**WEST SUSSEX COUNTY COUNCIL
INFRASTRUCTURE CONSULTATION**

SUBJECT: BR/274/09-Change of use from arcade (Sui Generis) to restaurant (A3).

2, Waterloo Square, Bognor Regis, PO21 1SU

BIN
STORAGE

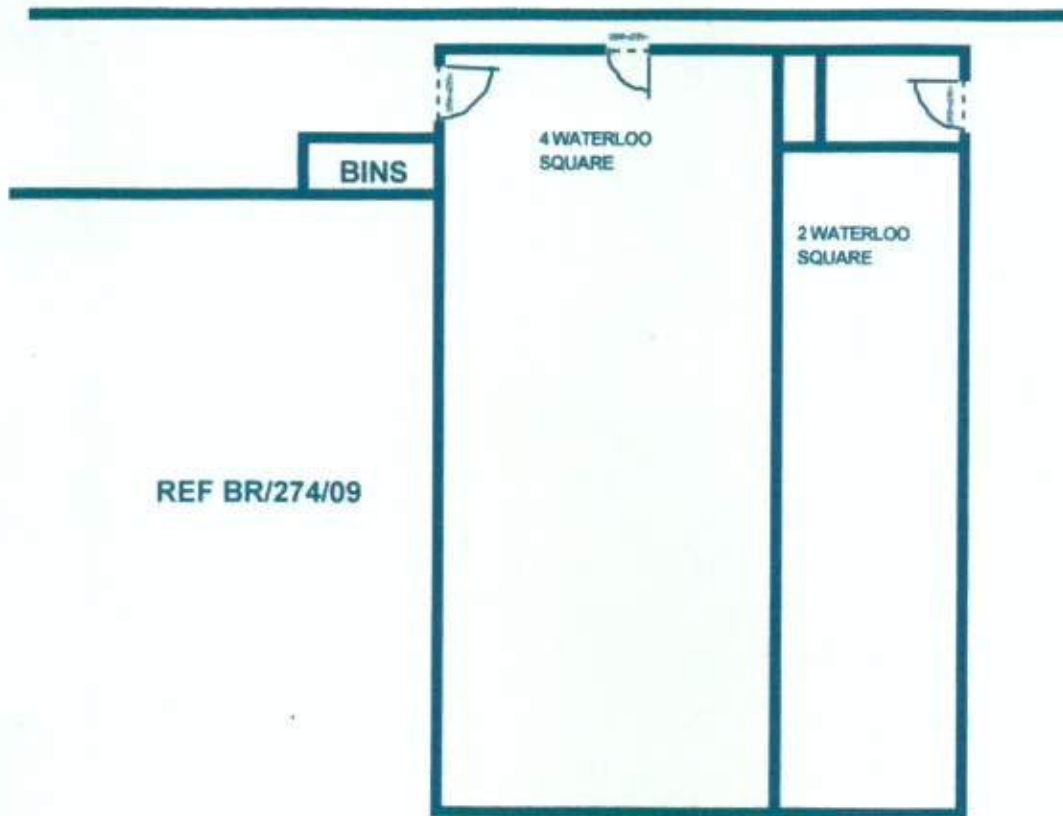
The current use for an arcade has been in existence for sometime. I am not aware of any adverse comments that may have been made by the Highway Authority, or of any other highway related concerns with this site and the current use. Therefore, I would not foresee there being any significant highway issues to this change of use being implemented. The site is located centrally to the commercial/retail/ business sites in Bognor Regis, it is anticipated that customers to the proposed restaurant will use more sustainable modes of transport to access the site. The applicant should ensure they have adequate bin storage as this change of use could generate more waste than the previous usage.
